Re: 1441 Woodward SE – Retaining Wall Evaluation - Follow up

RE: **Property located at 1441 Woodward Rd. SE**
Albuquerque, NM 87106
Retaining wall concerns
File: M15D23B

**Re: Candlewood Suites, Lot 2-A Sunport Park Grading and Drainage Plan
Engineer's Stamp dated 6-18-08, (M15/D23B)**

RE: CONCEPTUAL DRAINAGE PLAN FOR FRONTIER SYSTEMS, INC. (M-15/D23B)
ENGINEER'S STAMP DATED JUNE 4, 1990 RECEIVED JUNE 4, 1990

RETAINING WALL PROFILES

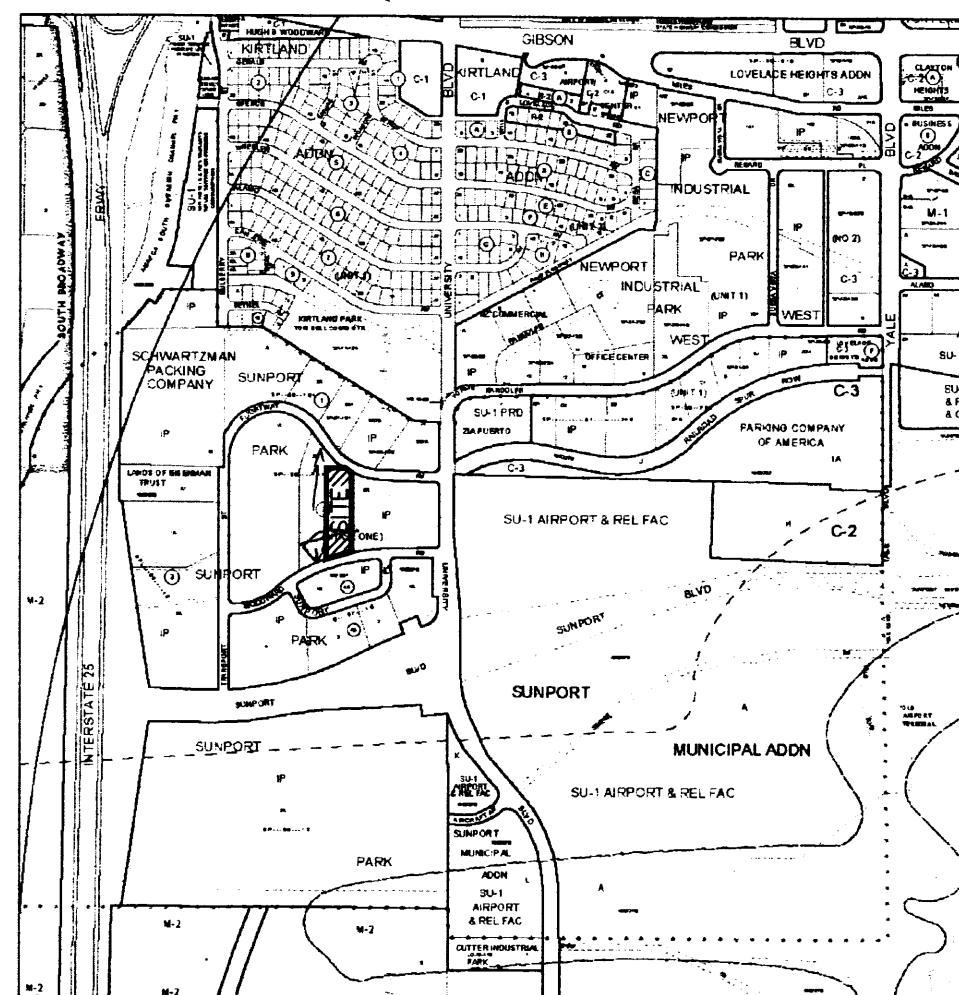
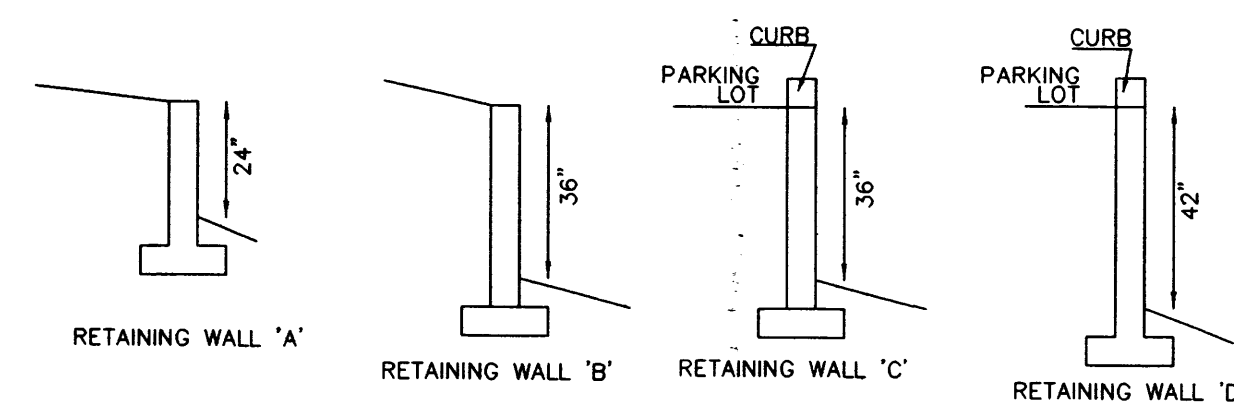
1. If you are accepting off-site flows from the east, how will they be accepted with the proposed retaining wall in place?
2. Eliminate the contours that cross the proposed building.
3. Please indicate the top of curb and flowline elevations for both Woodward Road & Flightway.
4. Your calculations for the Woodward pond calls for 2-8" P.V.C., but you indicate 2-6" P.V.C. please address.
5. Elevation at property line must be 1" foot above the street flowline.
6. Indicate the direction and location of the roof drains.

7. Top of retaining wall elevations, please indicate on plan drawing.
8. Is there going to be a replat? If not, the cross-lot-line drainage issue must be addressed.
- 9 What type of slope protection will be implemented on the steep slopes.

DRAINAGE AND GRADING PLAN
 CANDLEWOOD SUITES
 LOT 2-A-3, BLOCK 4-B, SUNPORT PARK
 FOR: KAREEM KASAM

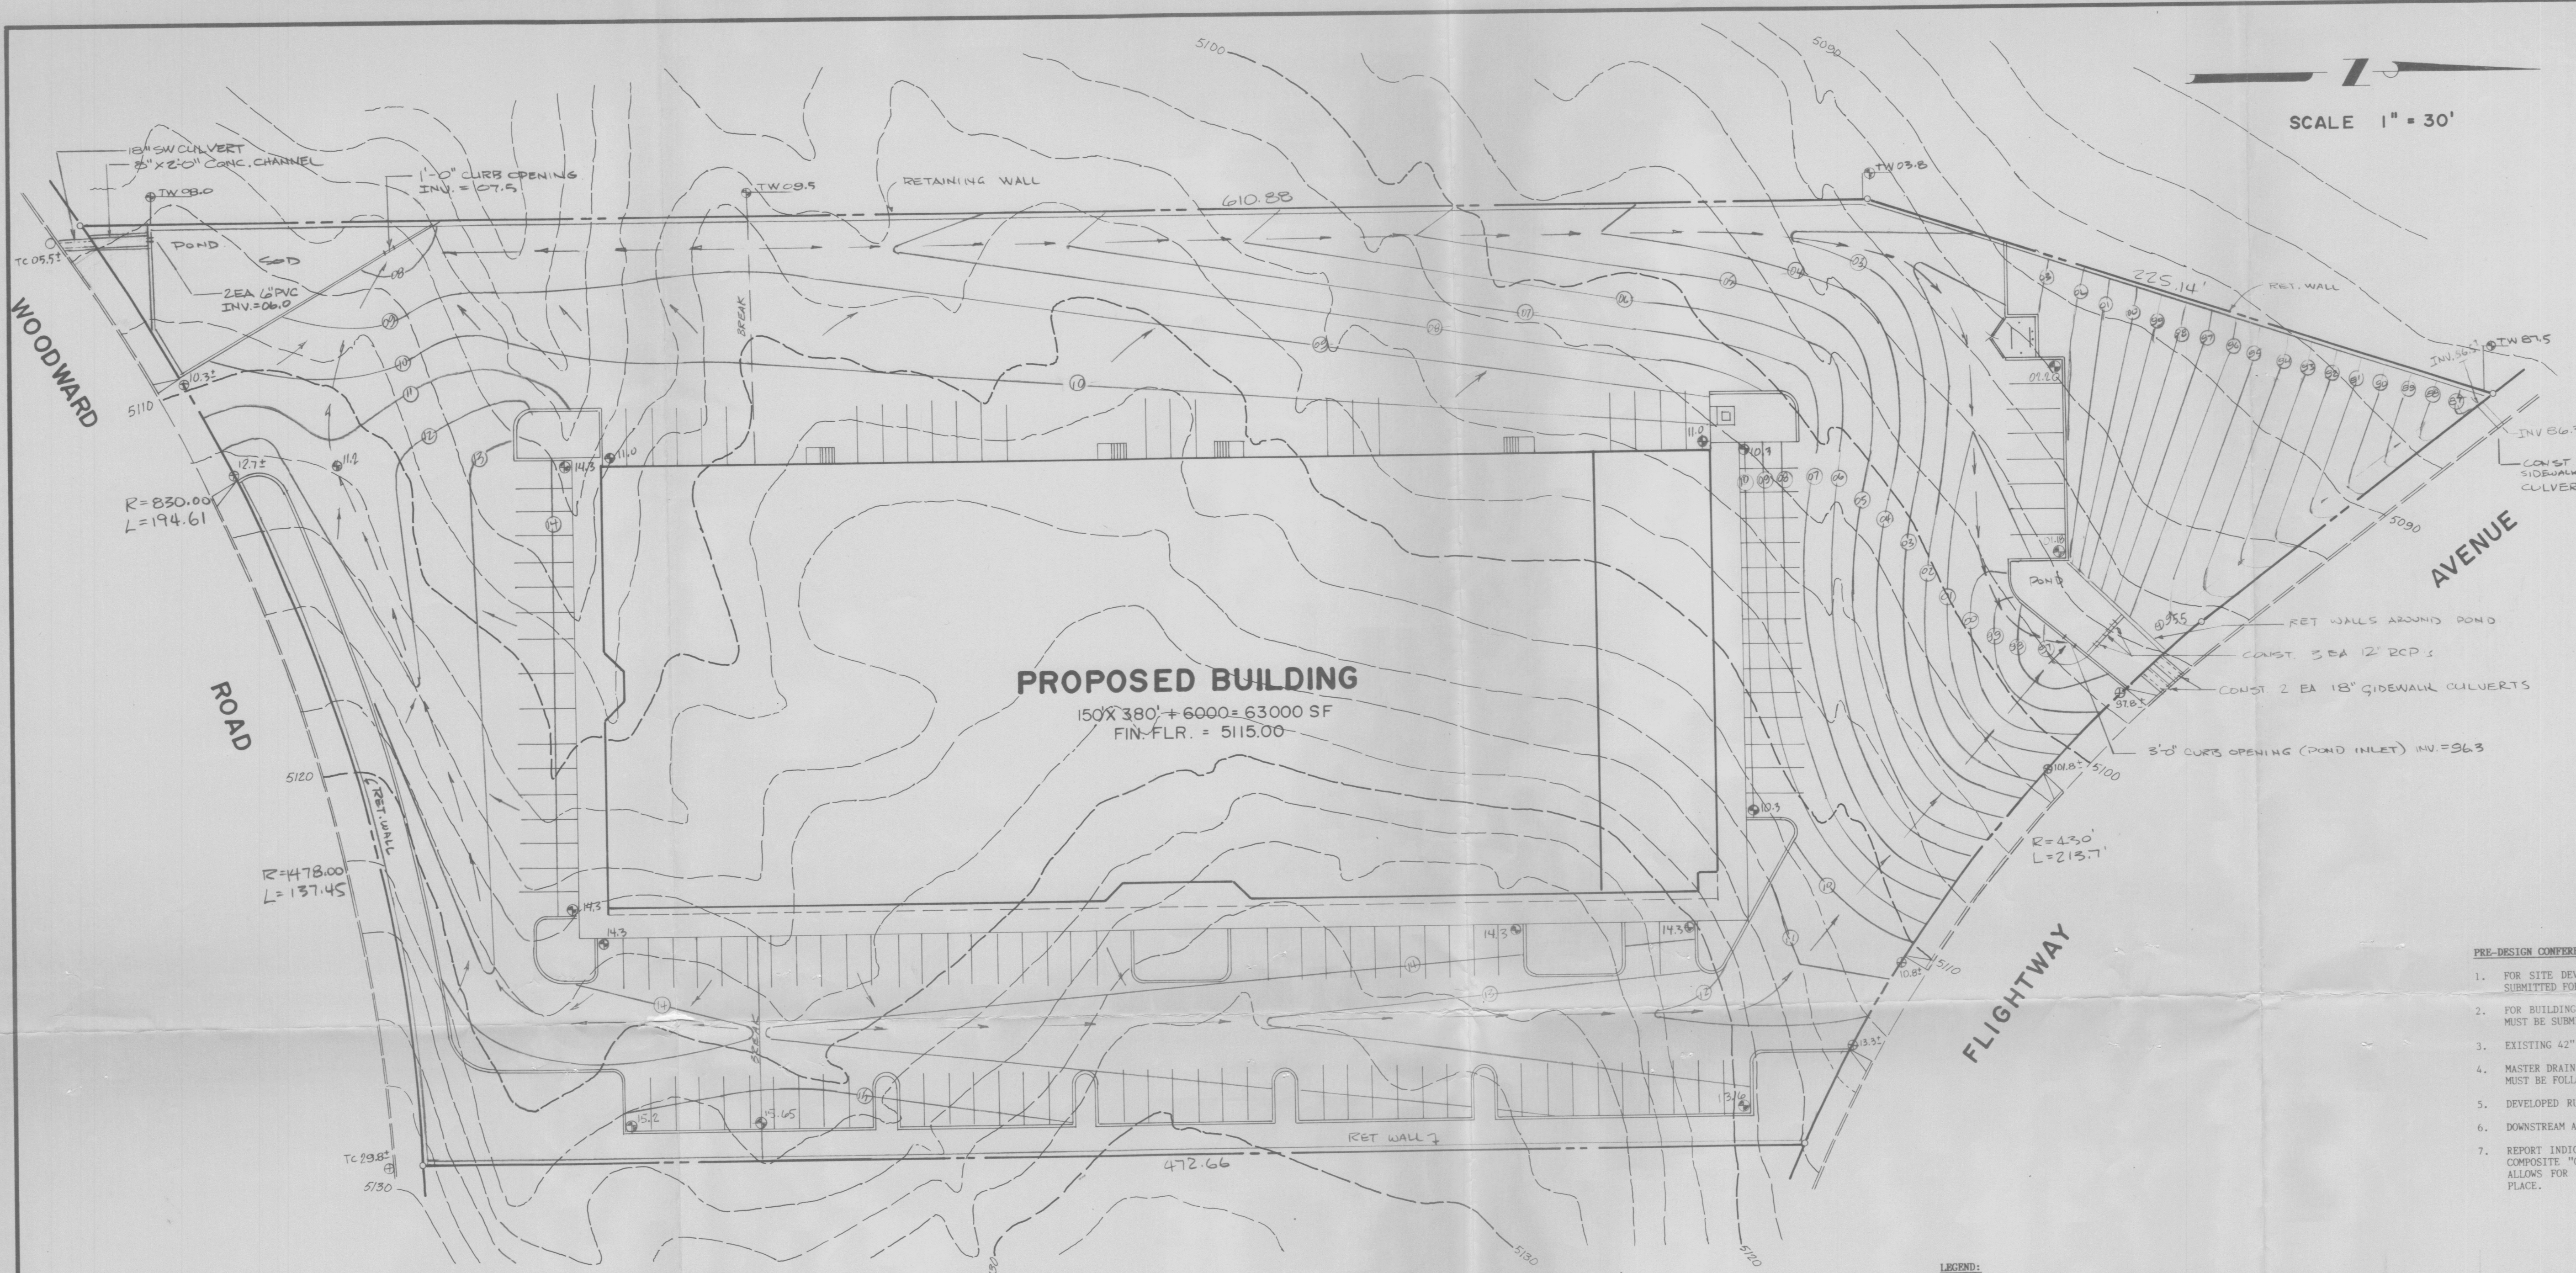
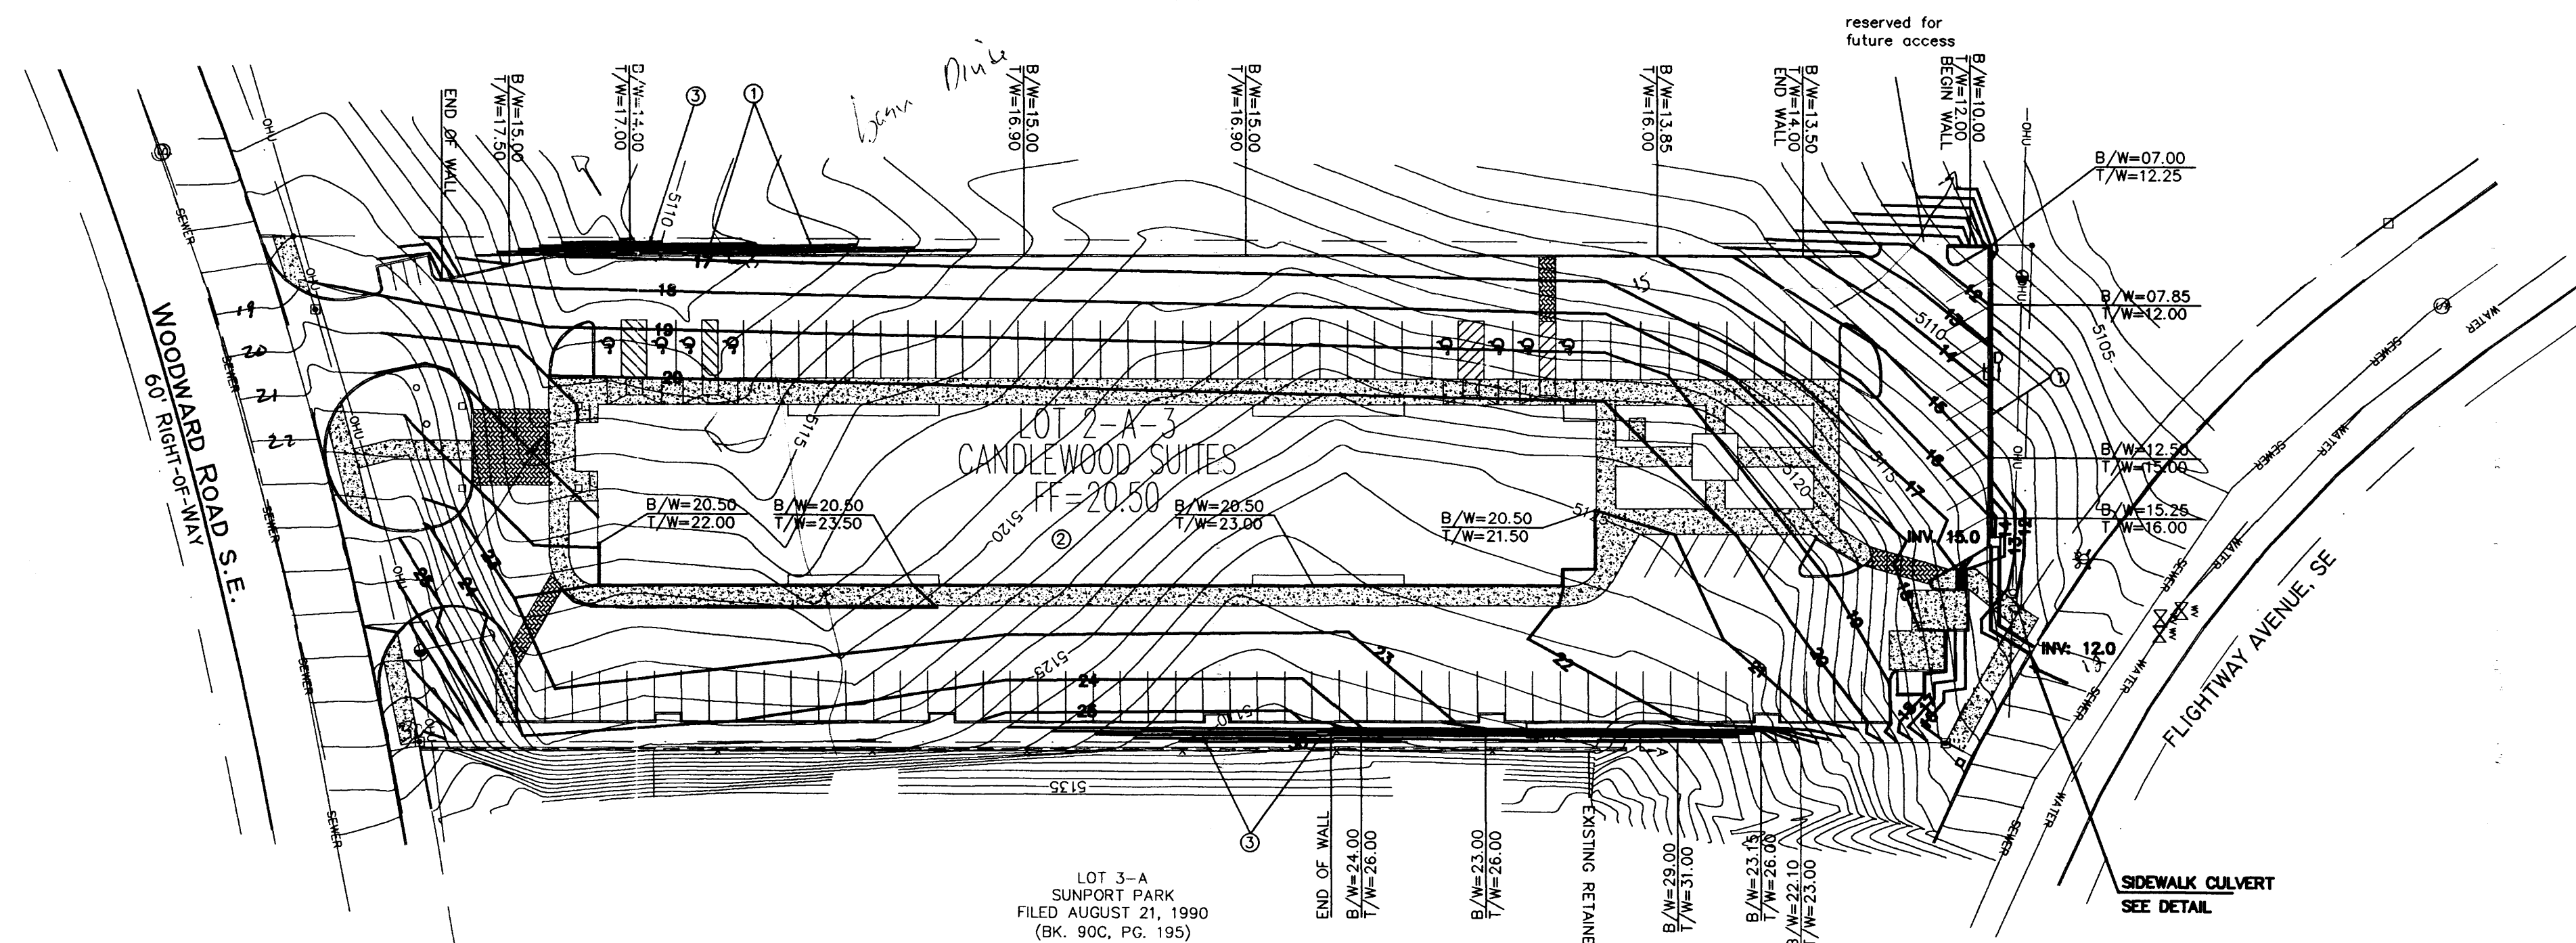
- a conceptual plan addressing all lots created in the plat should included in order to adequately design any retaining walls needed.
- How will the runoff programmed to go Lot 2-A-2 be addressed.
